Our Ref: BN/126/21/DOC

Approval of details reserved by condition imposed under ref W/4001228 (BN/24/20/PL) relating to Condition Nos 3 - materials and finishes, 5 - noise, 6 - dustbin enclosure, 7 - renewable energy, 10 - covered & secure cycle parking, 11 - electric vehicle charging, 12 - surface water drainage and 13 - foul drainage.

Tile Barn Farm 32 Hill Lane Barnham PO22 0BL

Arun District Council have decided to **APPROVE details reserved by this condition**

SITE PLAN

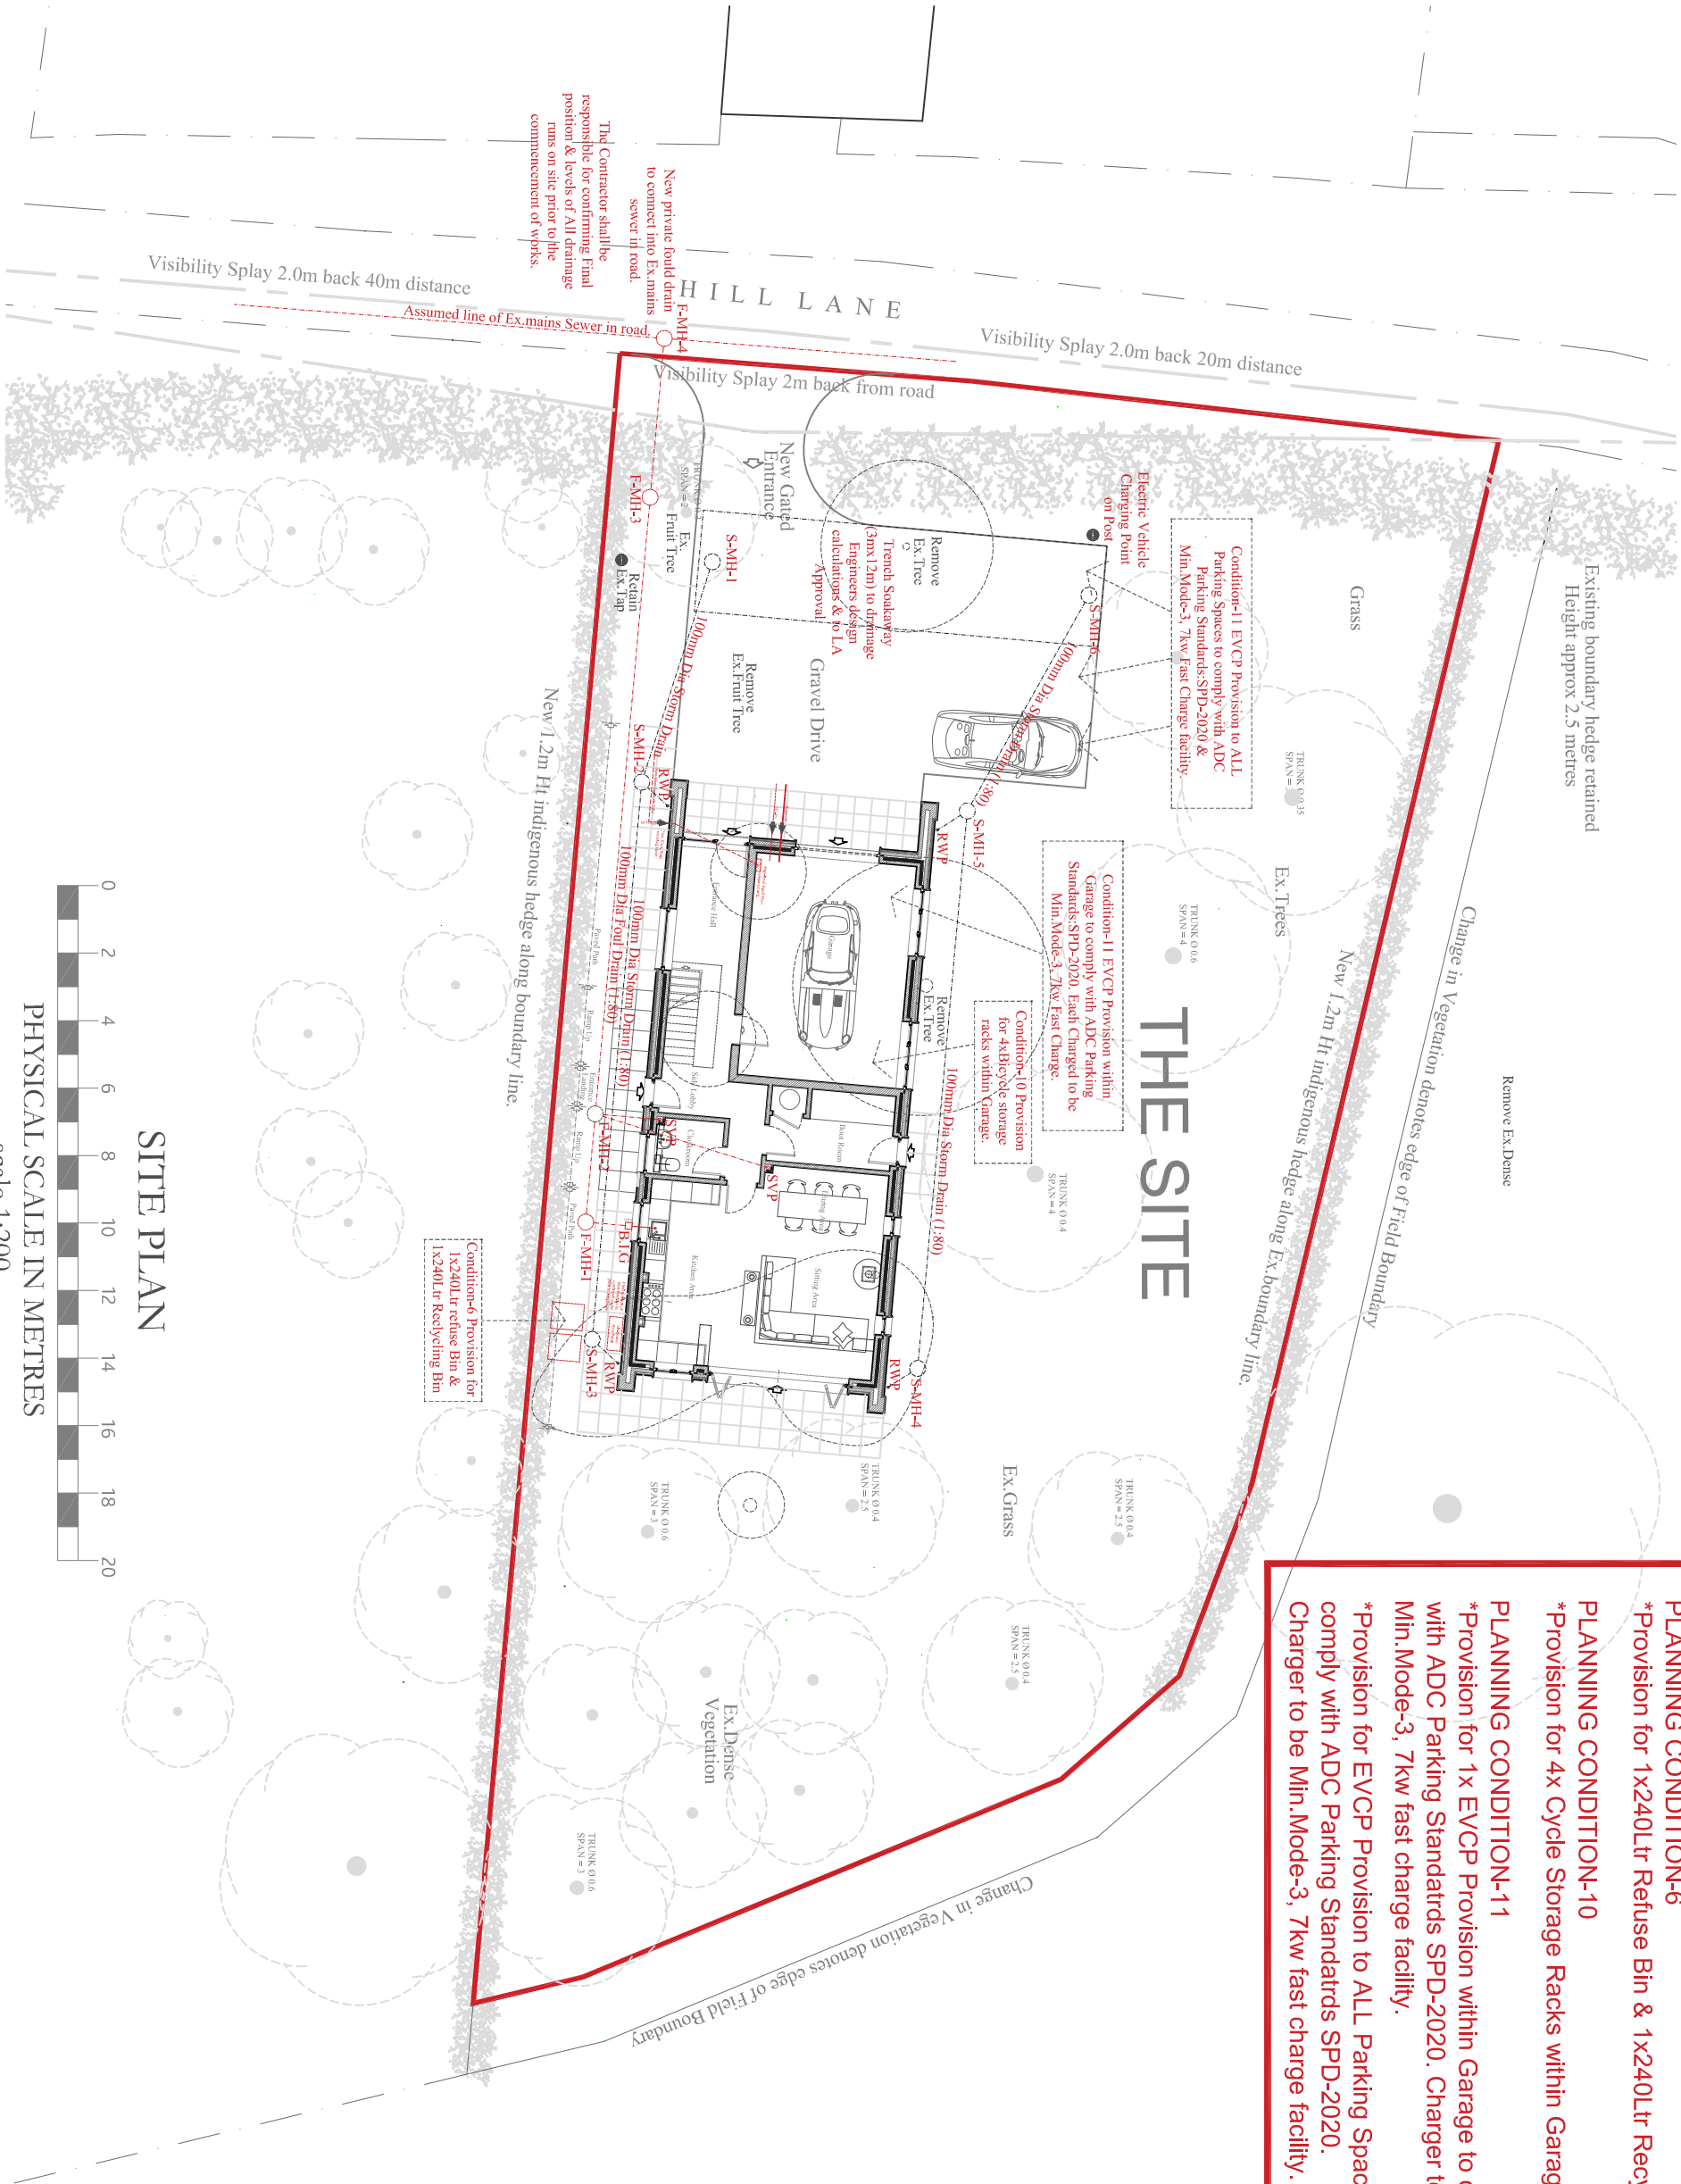
Officer comment: The revised Site Plan shows provision of 1 x 240l bin for refuse and 1 x 240l bin for recycling to serve the new dwelling. No dustbin enclosure is proposed, which is acceptable given location within site, boundary screening and lack of visibility.
